COMPLETED 02/24/06 STH DRB CASE ACTION LOG (FINAL PLAT)

DRB Application No.: 06DRB-00129 (FP)

Project # 1004139

Project Name: MODESTO SEVEN

**PLAT OF  
 MODESTO SEVEN**

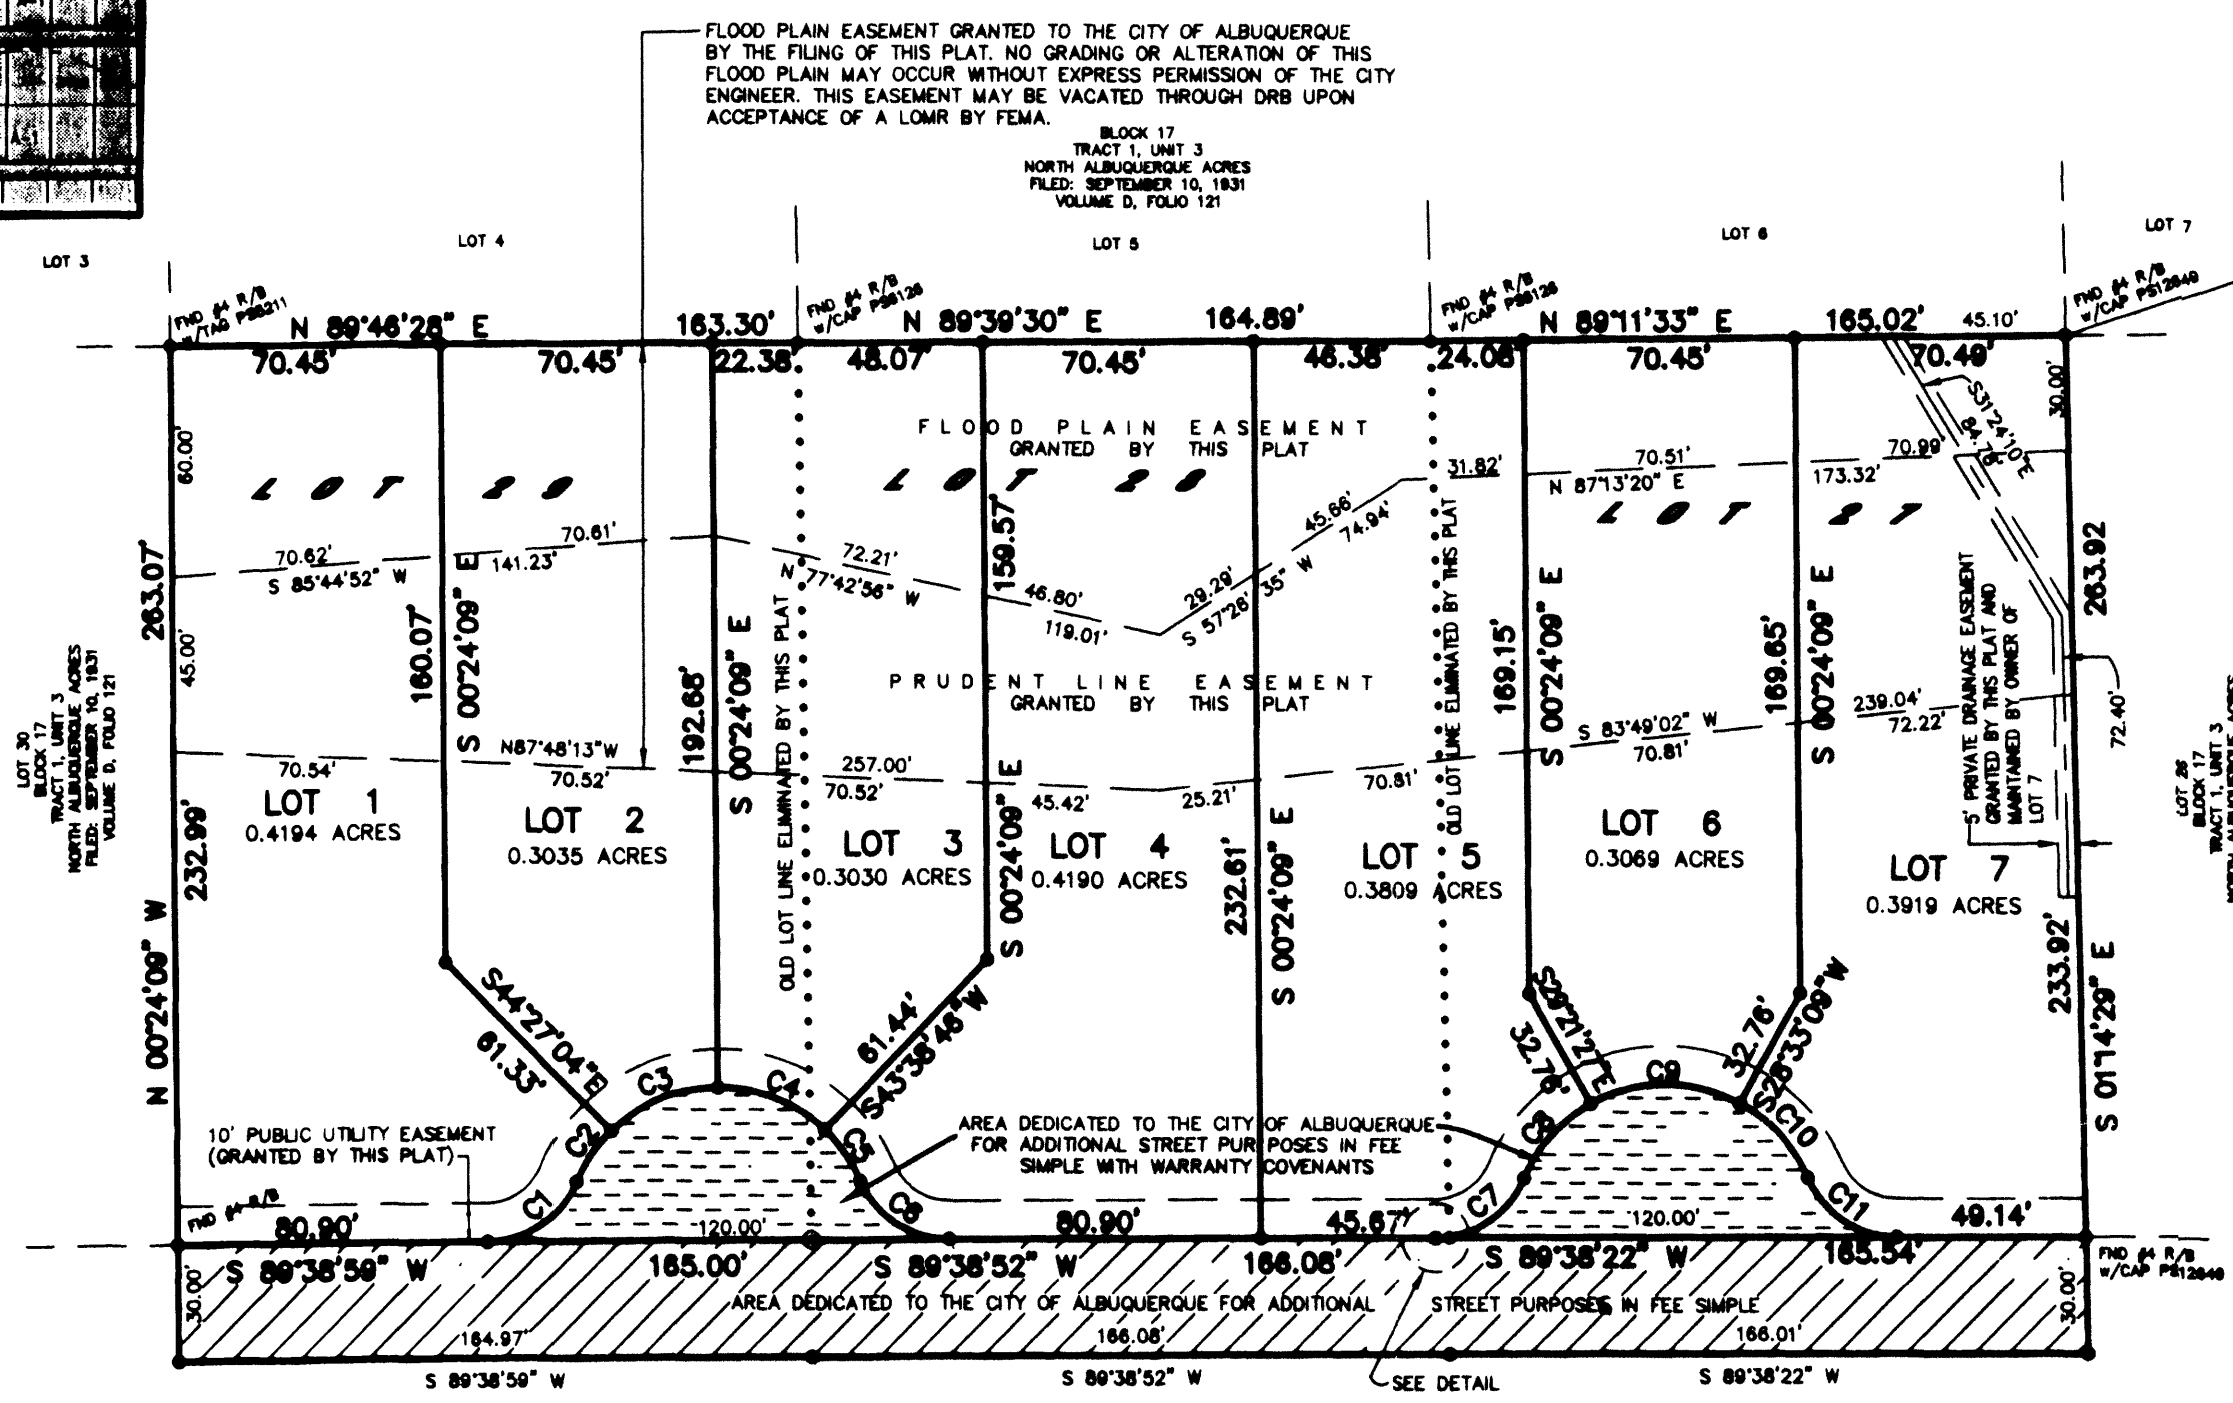
TRANSPORTATION: P-1 lot designation *dk gwt*

TRANSPORTATION: Plat designation

Has anything changed from preliminary plat?

AGIS dxf is not on file.

Planning will take delegation for the AGIS dxf approval, and to record the plat..
